Application: SSI 7485

I write regarding the proposed modification to M4-M5 Link, Mod 2 The Crescent overpass and changes to pedestrian infrastructure in North Annandale, Rozelle and Rozelle Bay Foreshore area.

Figure 4-2 Pedestrian and cyclist bridge infrastructure options

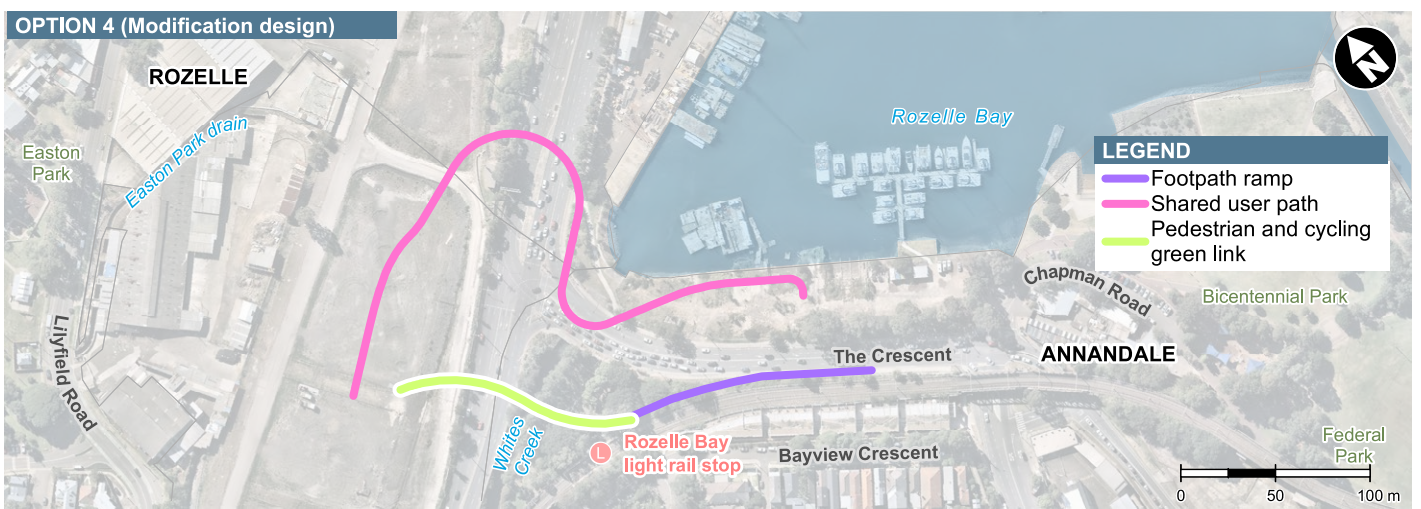
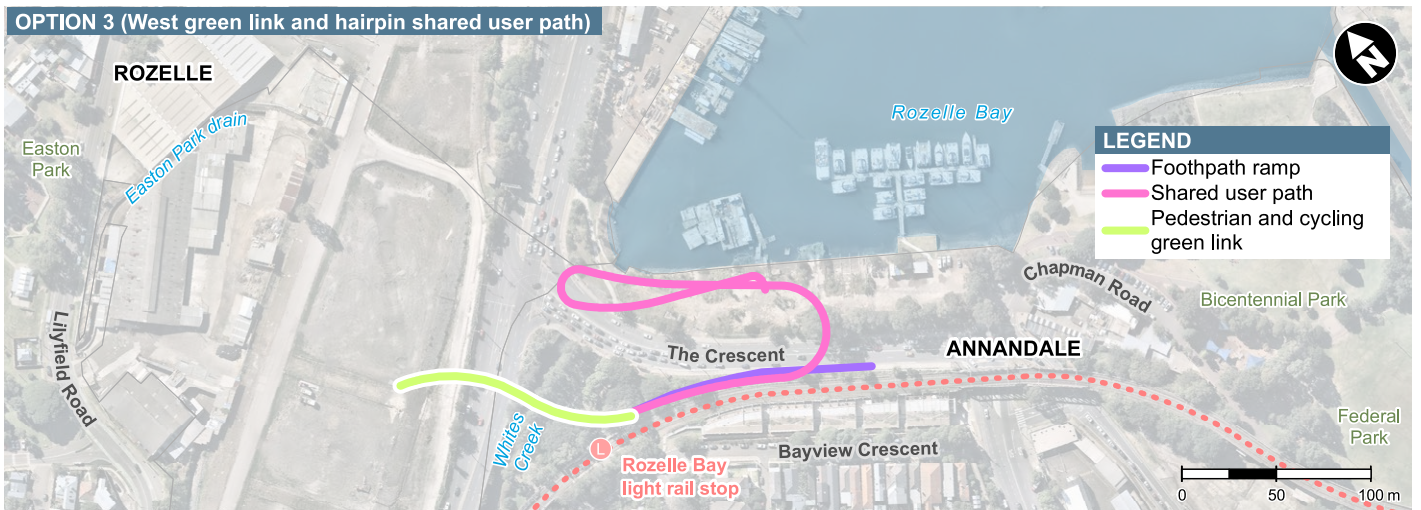
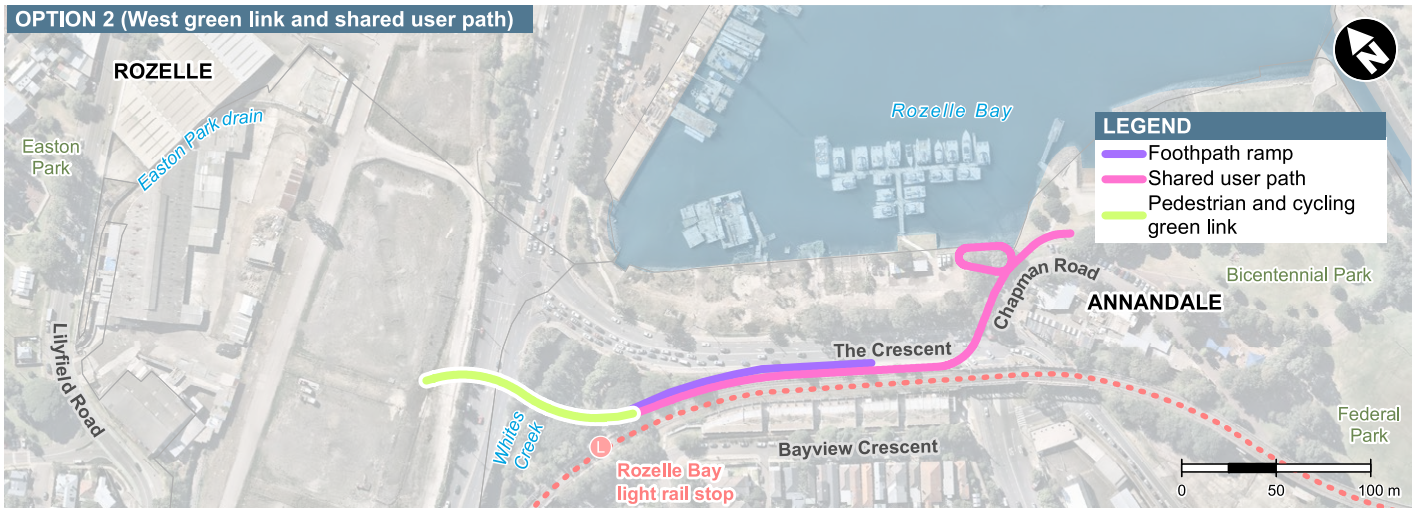
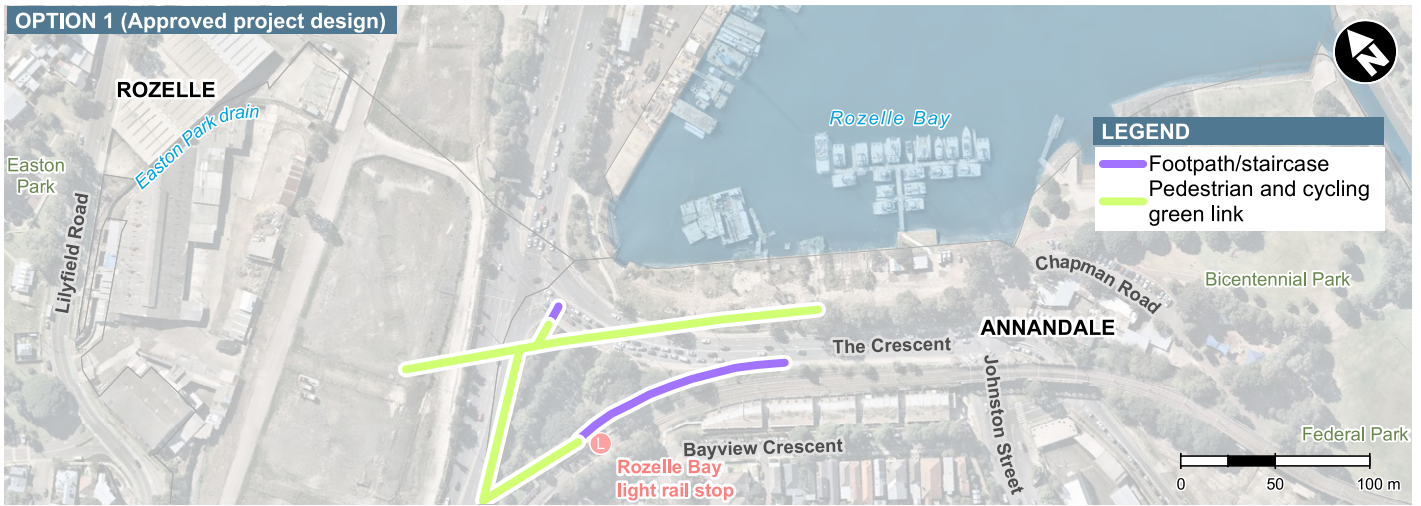
I request RMS work with the community to explore alternate design options to the proposed new car overpass design and the changed pedestrian and cyclist links. I am seeking the reinstatement of the safe, direct access from the approved EIS GreenLink to create a continuous green open space connection from the Rozelle Rail yards and Annandale to the foreshore. The GreenLink was more than just a walk way - it put people central to the design, maximising safety, and providing much needed accessible open space for the community now and into the future Bays Precinct design.

- The significantly reduced safety and increased risk for pedestrians and cyclists with removed access over The Crescent to Bicentennial Park and the increased traffic along Johnson Street.
- Being required to cross five sets of pedestrian lights at The Crescent as my option to reach the foreshore from Annandale or from Rozelle Bay light rail stop.
- Removal of direct active links to the foreshore, cutting the community off from the area and the proposed revitalisation of the entire Bays Precinct, including linking the Light Rail and Bus stops to a Ferry wharf and Metro station.
- Urban and landscape design that is being built before a finalised Masterplan for the area.
- Traffic changes that limit movements around the suburb and create further congestion in the local streets of Annandale, Forest Lodge, Glebe, Lilyfield and Rozelle with no planning to deal with these.

- Reinstate the GreenLink connecting communities and green open space from Rozelle to Bicentennial Park
- Relocate and design pedestrian and cyclist connections that are continuous, safe and direct.
- Design the modification infrastructure and active links in response to the character of the suburbs, the location of the foreshore and it's potential future development.
- Provide pedestrian and cyclist paths that maximise people safety and do not force them onto busier streets, unsafe concrete plazas and caged walkways.
- Integrate active and direct connections to all active transport – including the future Metro West and Foreshore Ferry Wharf

Figure 4-4 Elevation: Indicative view of The Crescent overpass

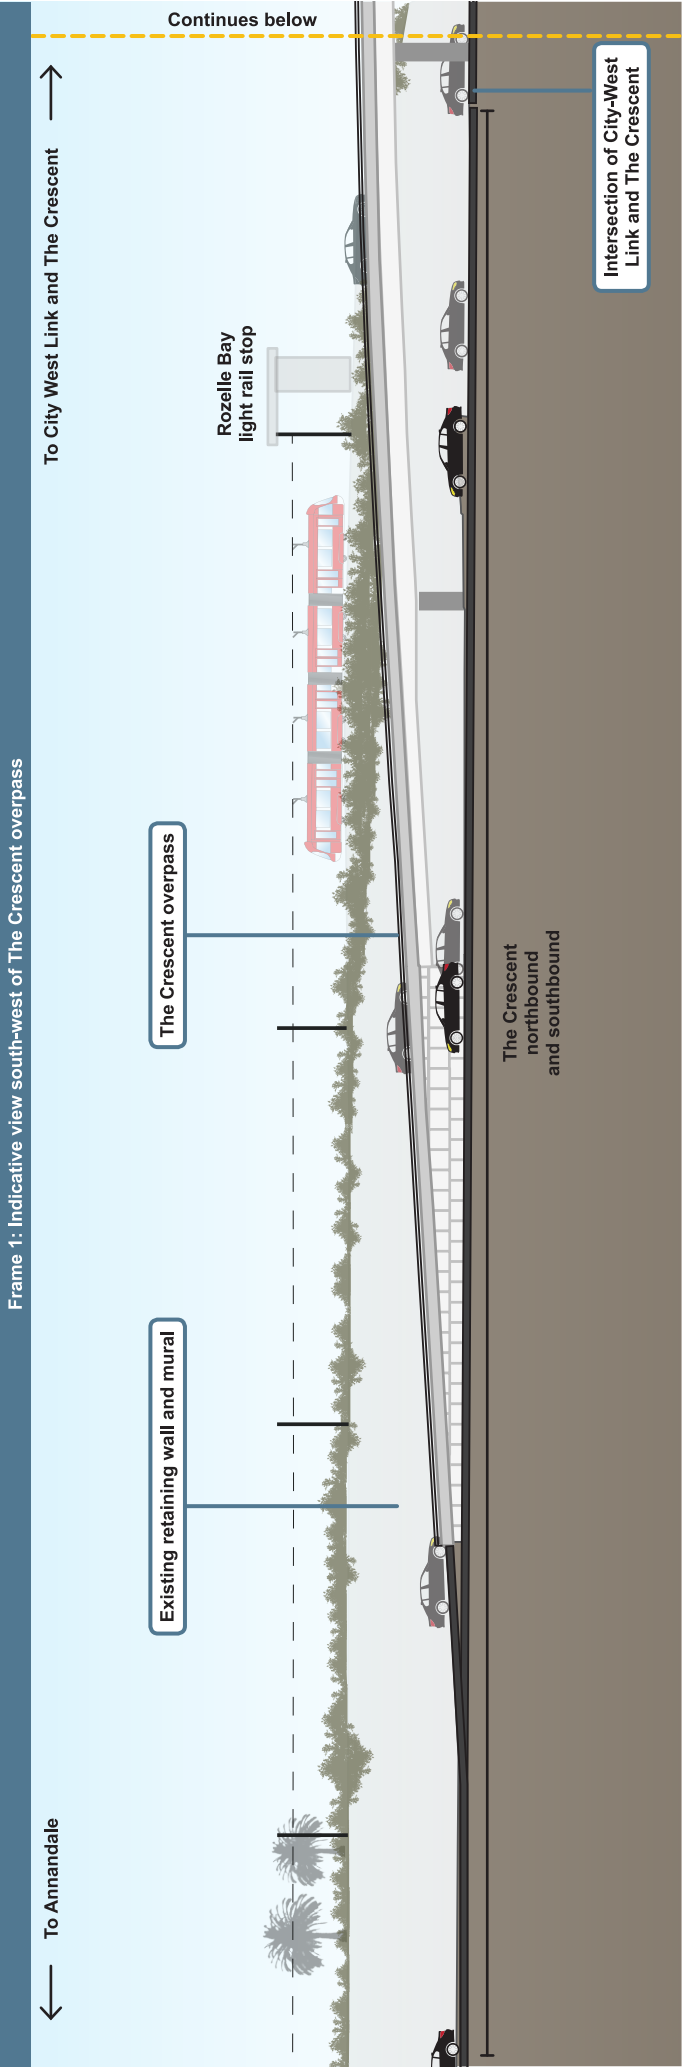
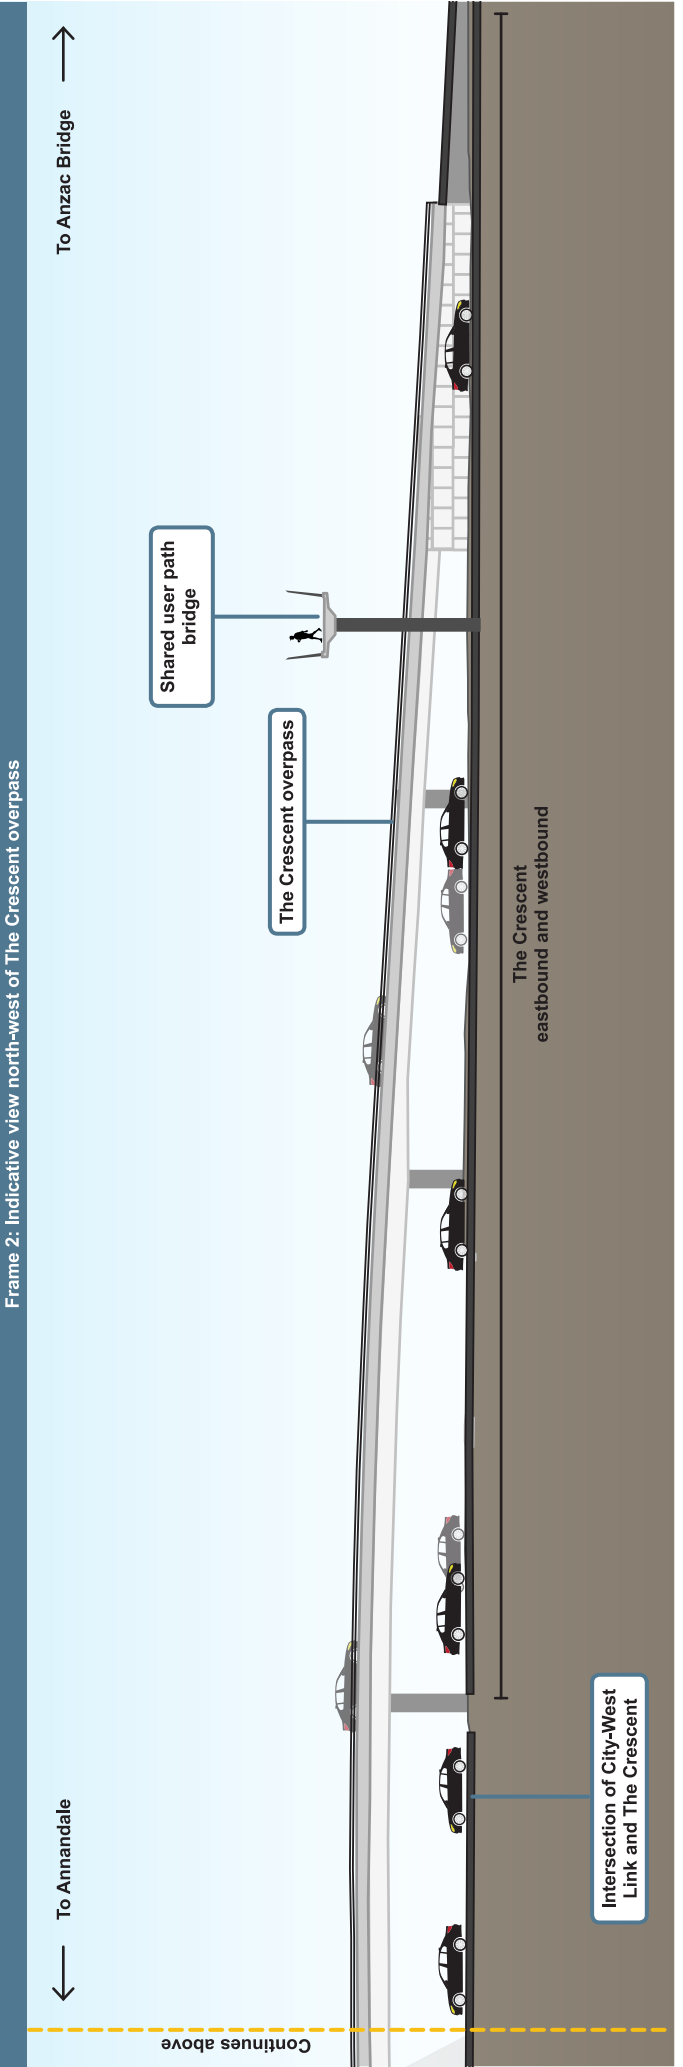
I strongly object to this proposed modification,
this will detract from the natural beauty of
this area and will be a complete eyesore.
